**MECKLENBURG COUNTY**  
Park and Recreation Department

MEMORANDUM

**DATE:** April 16, 2008

**RE:** Rezoning Petition # 2008-059 Belgate (Doby Creek)

SHOPPING CENTER DRIVE EXTENSION (for future flyover)  
DETAIL 1

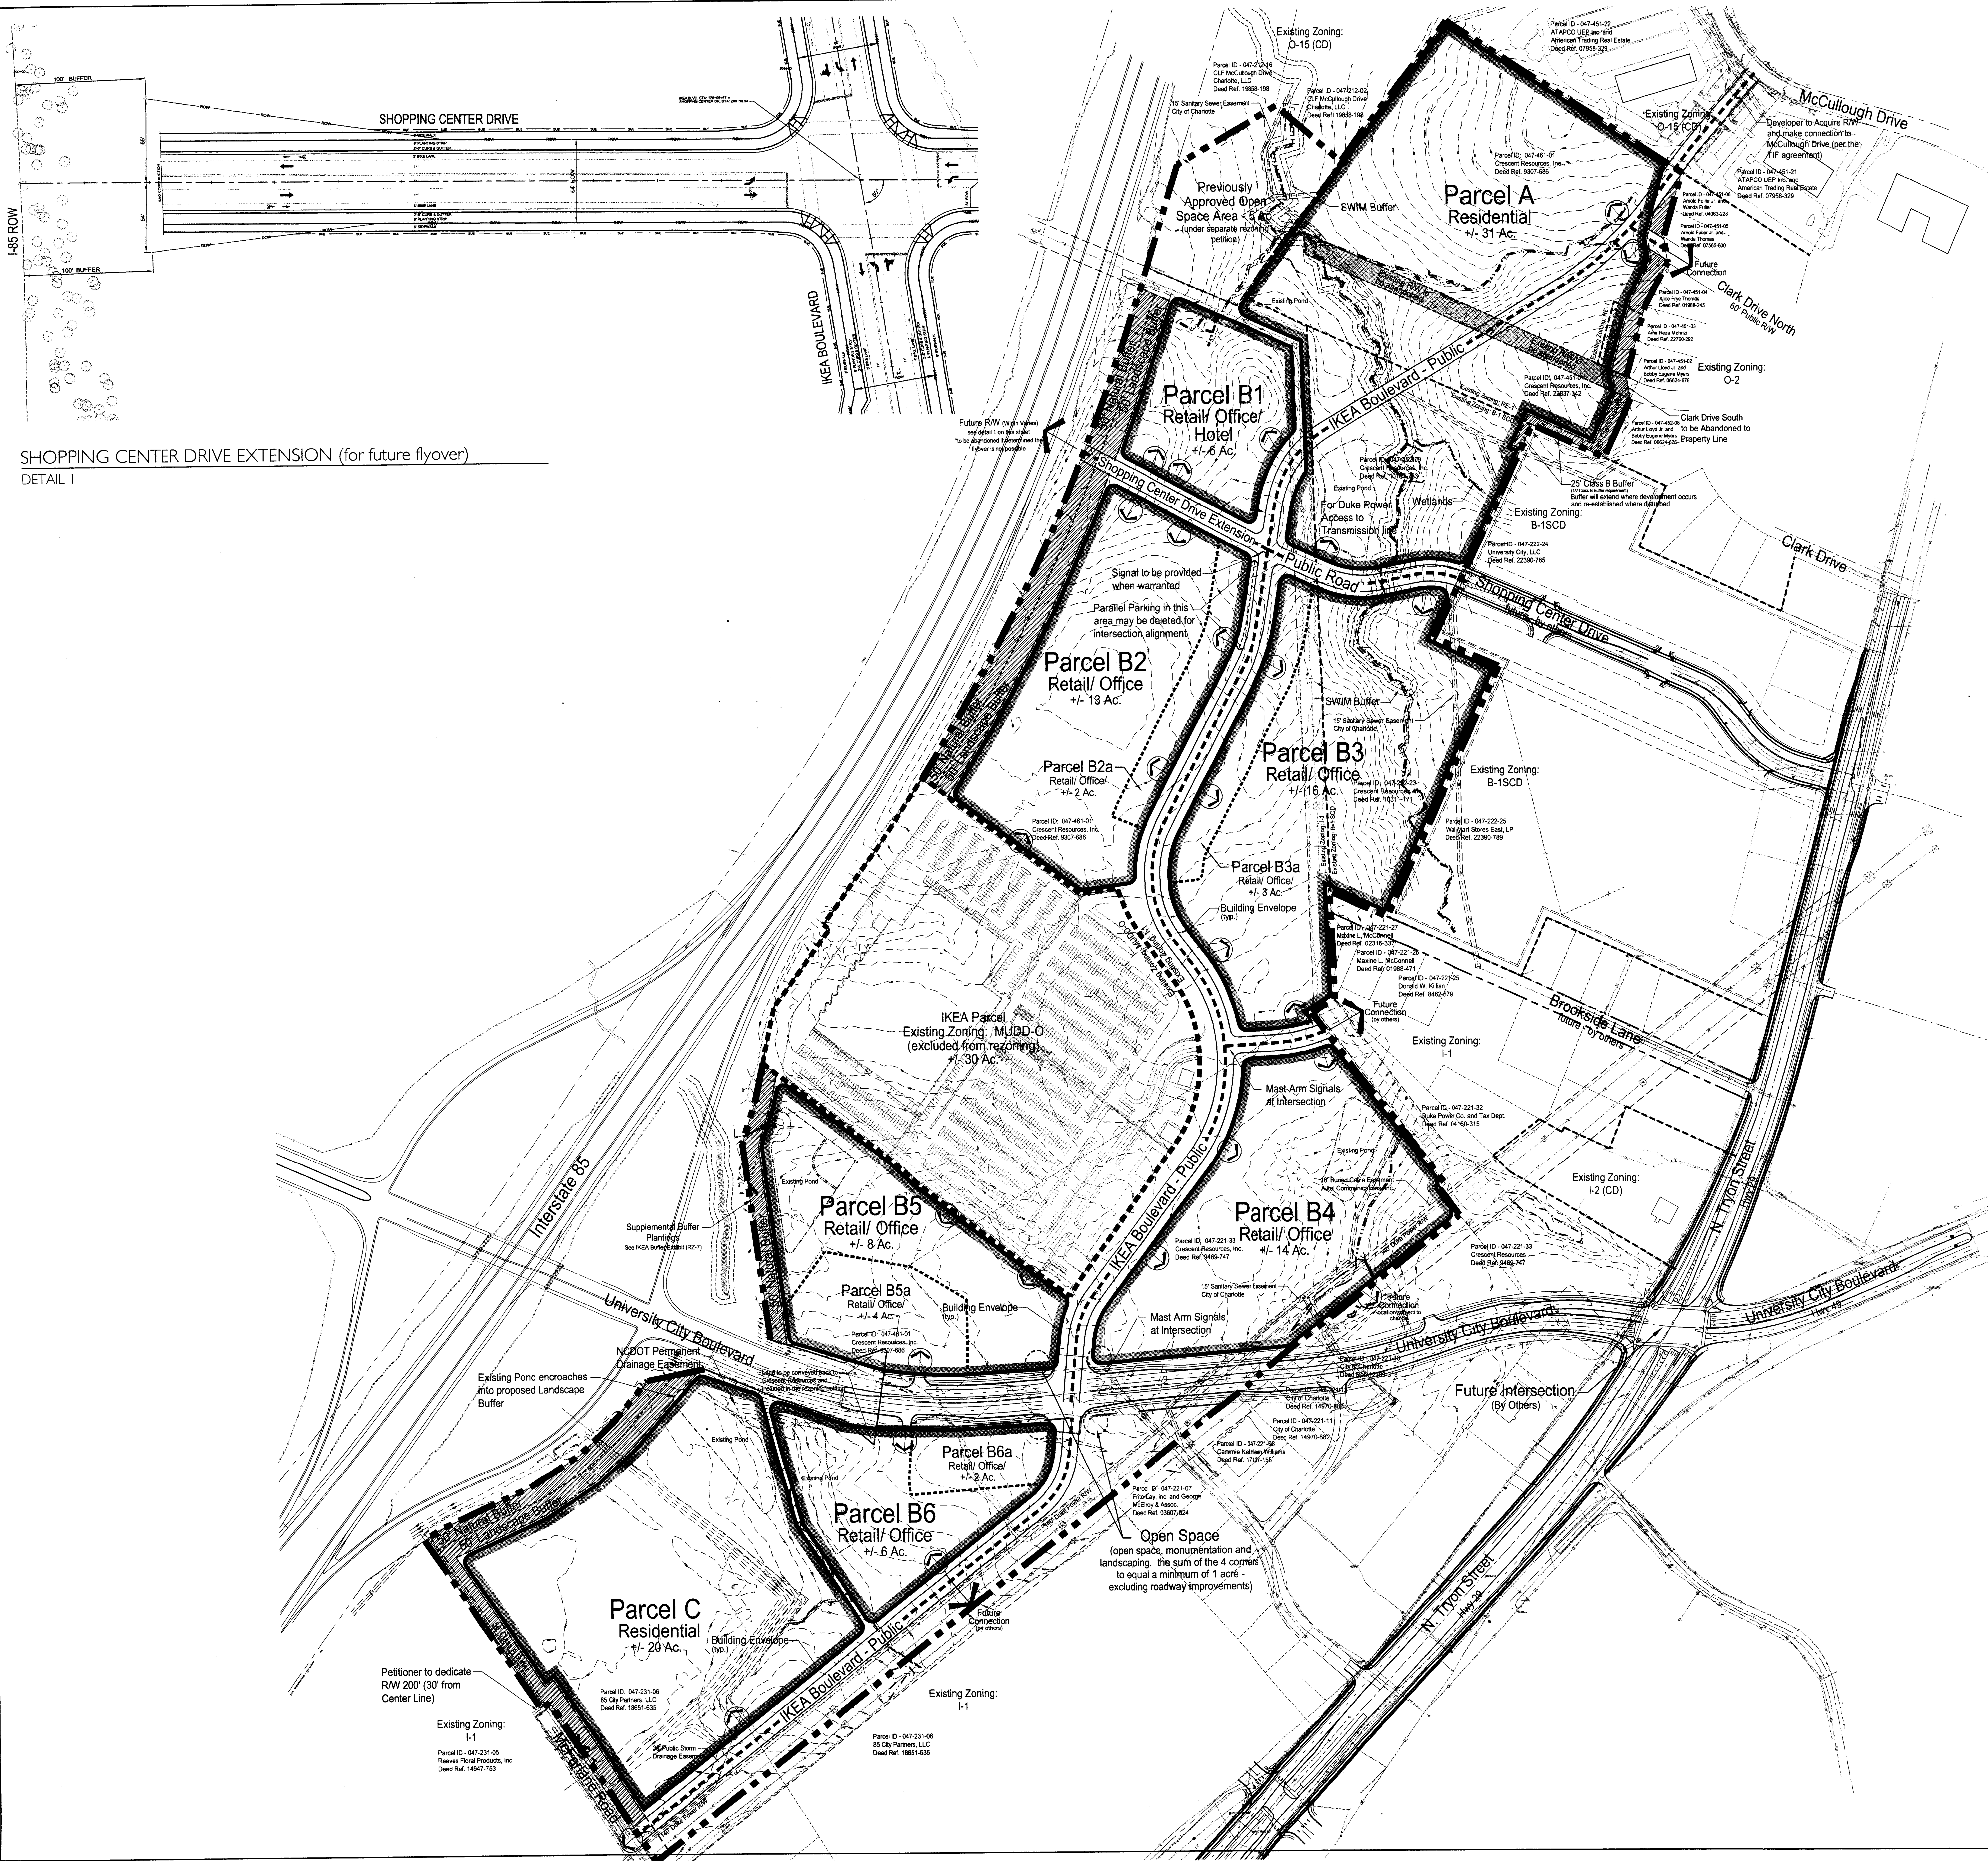
- MCPR will continue to work with CDOT to refine comments.
- MCPR requests that the petitioner provide 8' wide sidewalks on both sides of Shopping Center Drive in lieu of the 6' sidewalks shown on sheet RZ-2 dated 1.28.08 and bike lanes that connect to the proposed Lynx transit station. The petitioner has committed to provide bike lanes on both sides of Shopping Center Drive.
- The petitioner has committed to provide bike lanes on Ikea Boulevard as well as 8' sidewalks and 8' planting strips on both sides of the road. MCPR has no further comments.
- MCPR requests that plans for the future bridges over I-85 allow minimum 8' wide sidewalks on both sides and bike lanes.
- MCPR requests that the petitioner provide an 8' wide sidewalk on both sides of City Boulevard and bike lanes if permissible by NCDOT.
